May 16, 2002

Subject: Milton Street Subdivision Swale

333
CBL/EQ28 and G1

Drawing Name:	Conceptual Development Plan
Project:	MILTON STREET EXTENSION

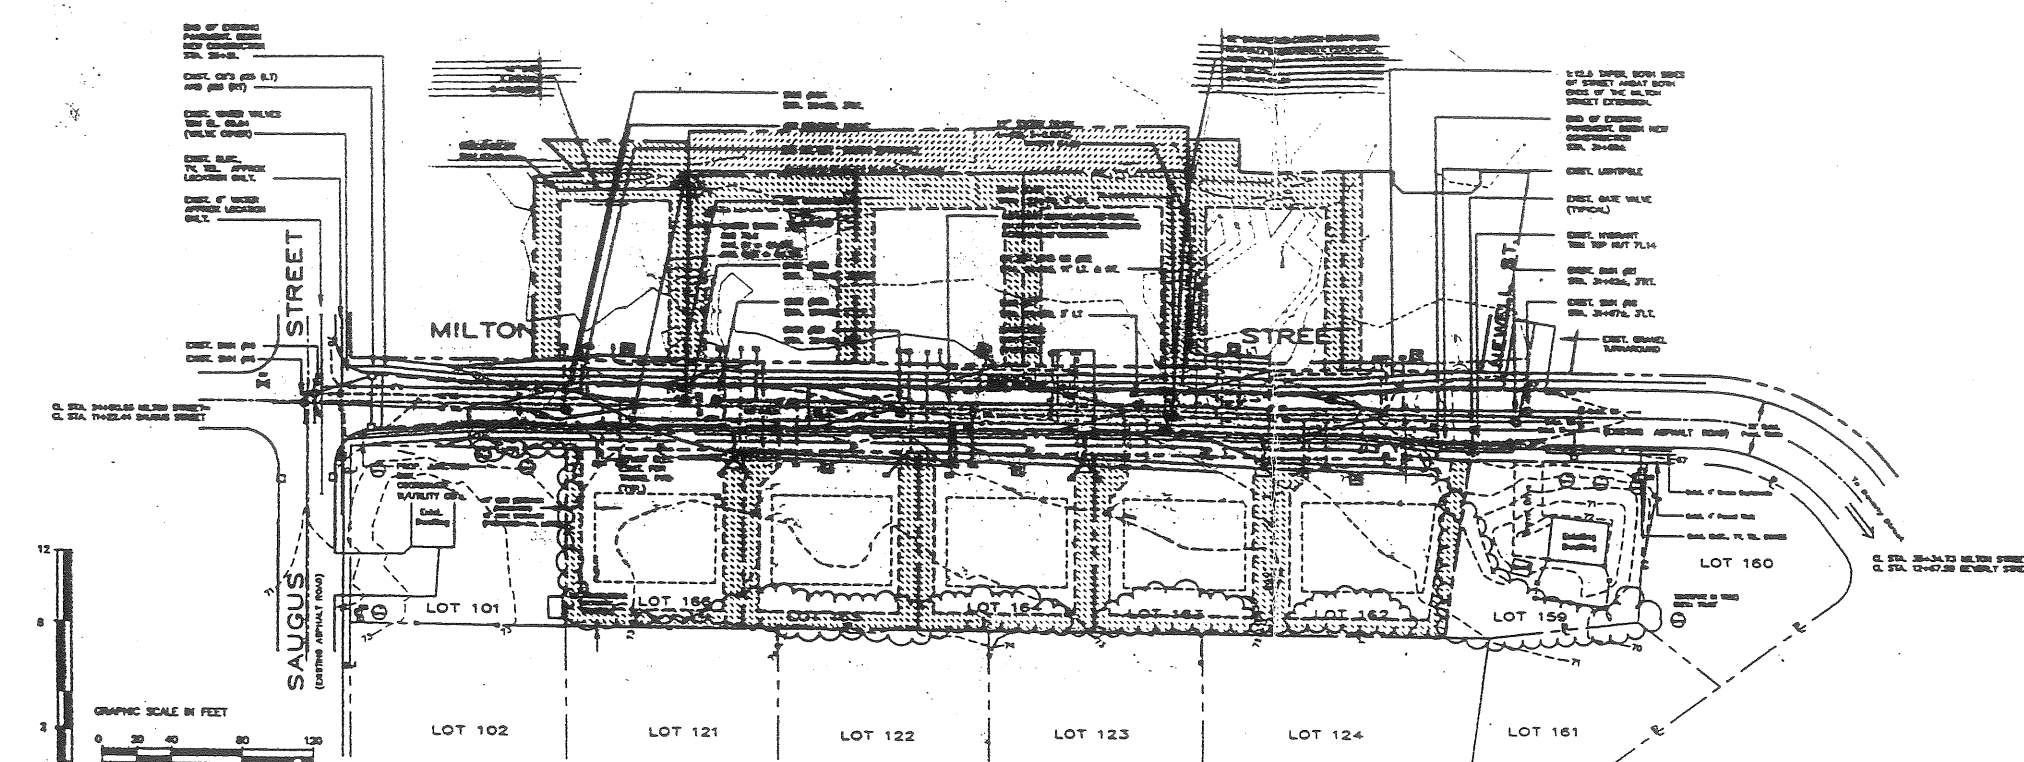
It was found that the swale has not been constructed in accordance with the subdivision plan. In particular, the contours/elevations in the grading of the swale vary from the site plan. Also, the Catch Basin/Field Drain rim elevation has not been set to the proposed elevation. This occurs behind all the lots on the Westerly side of Milton Street. The drainage appears to be functioning behind lots #167 and #168 to a certain degree. The drainage behind lots #169, #170, and #171, however, is not working very well.

At this time, the City requests that the swale be installed per plan to insure proper drainage. The field inlet rim also must be mortared to the structure at the correct elevation, and a grated cover still needs to be placed. If you wish to pursue any changes from the site plan, you must apply to the City for an amendment to your site plan.
